Subject: Planning Application No. A/248/21/PL : Land North of Water Lane, Angmering - Variation of Condition 4 (A/40/18/OUT)

Environmental Health:

Noise. I refer to Phlorum Noise Assessment, Project No. 10574, Revision 002, 19 November 2021.

Nearest Proposed Residential Properties to Industrial Noise Sources

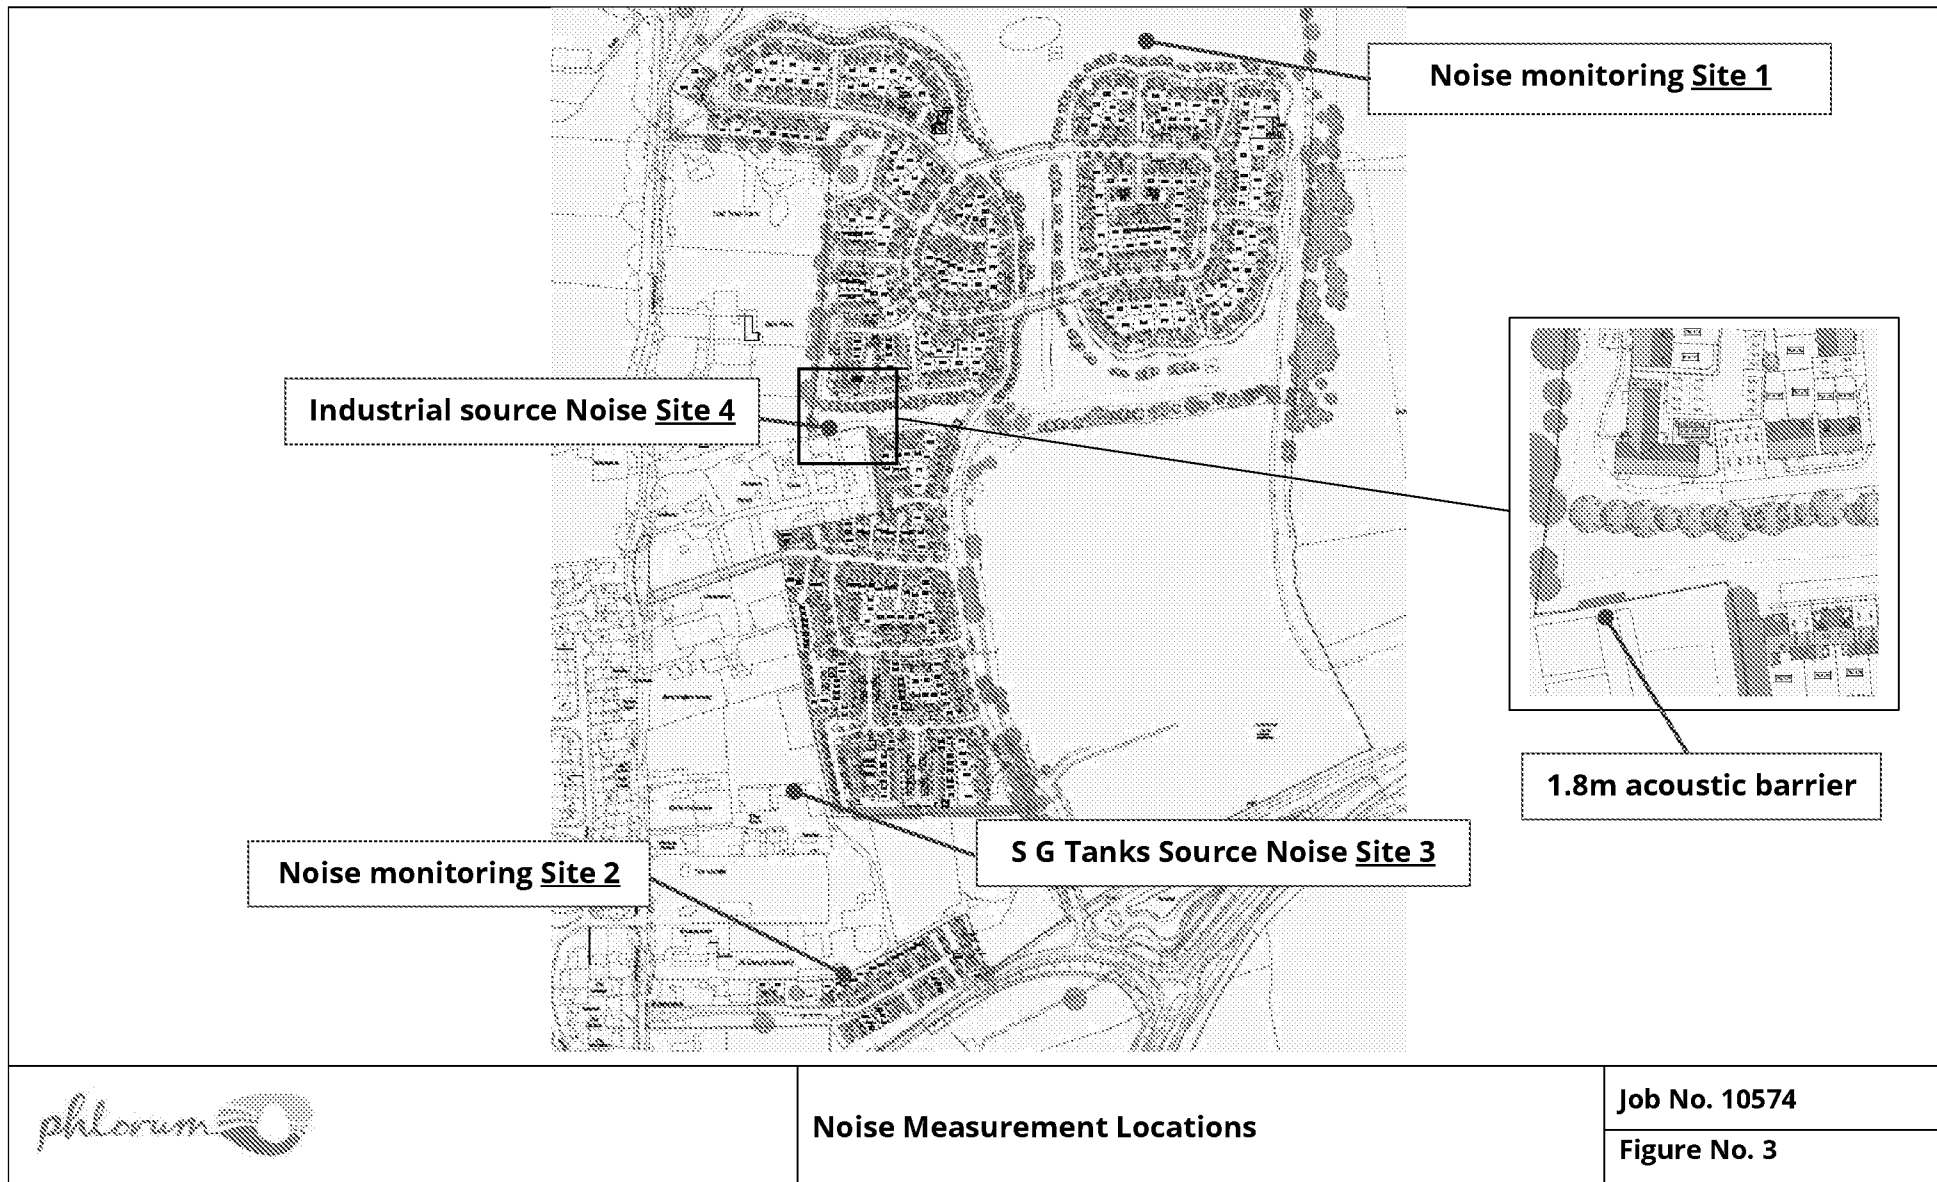
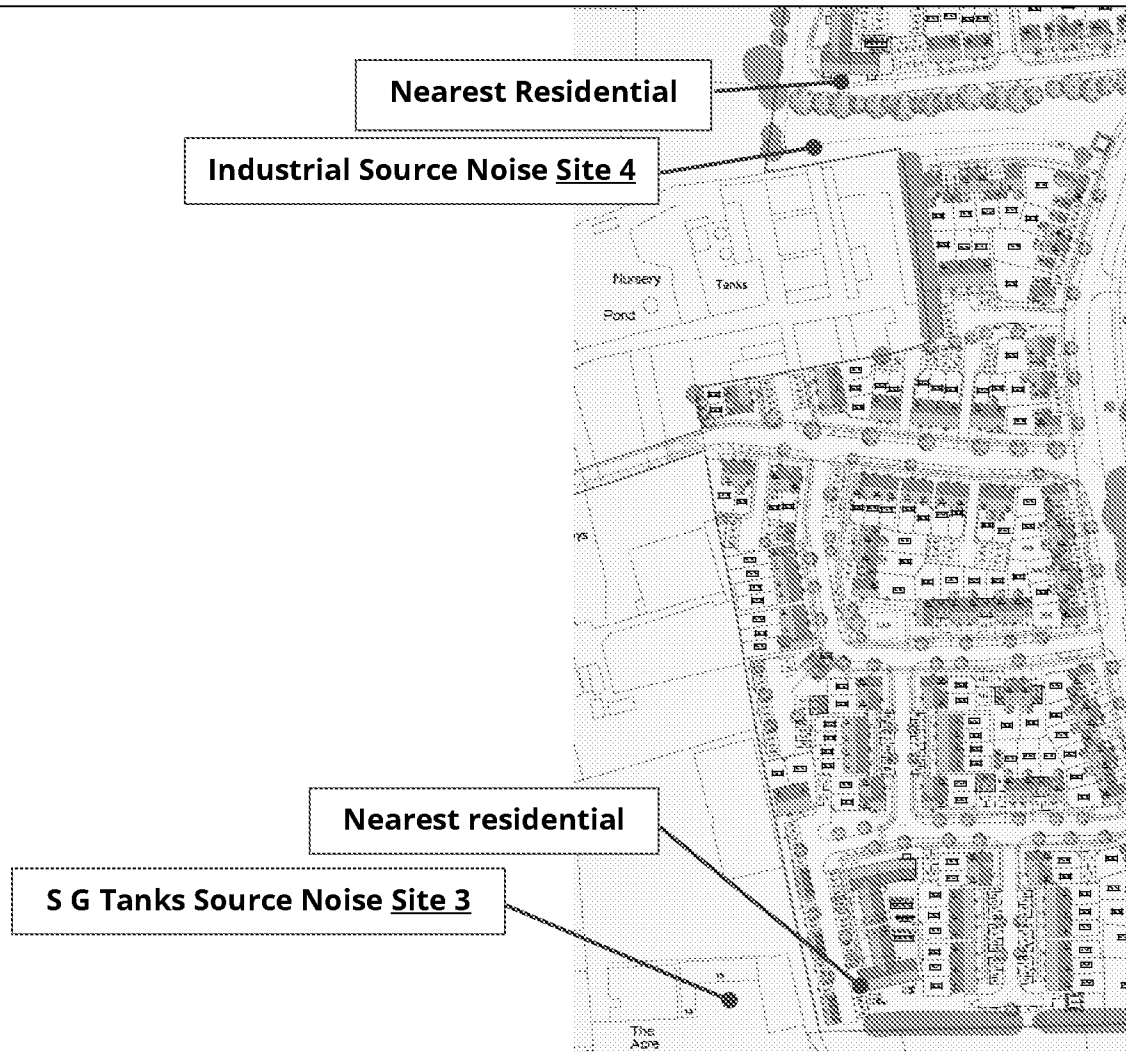
If granted, this variation would bring noise sensitive dwellings approximately 25m closer to a primary noise source, the A27. The developer appears to propose using these repositioned houses as a noise barrier to the rest of the site. It is of course, possible for the building fabric to be constructed to achieve acceptable internal noise levels. However, as clearly stated in the Planning ProPG (and this report) 'solely relying on the sound insulation of the building fabric to achieve acceptable acoustic conditions is not considered good acoustic design.' Although the provision of suitable acoustic insulation to windows and mechanical means of ventilation based on MEV3 or 4 was considered acceptable for the layout of the site set out in

the outline planning application, moving noise sensitive dwellings substantially closer to the A27 is contraindicated
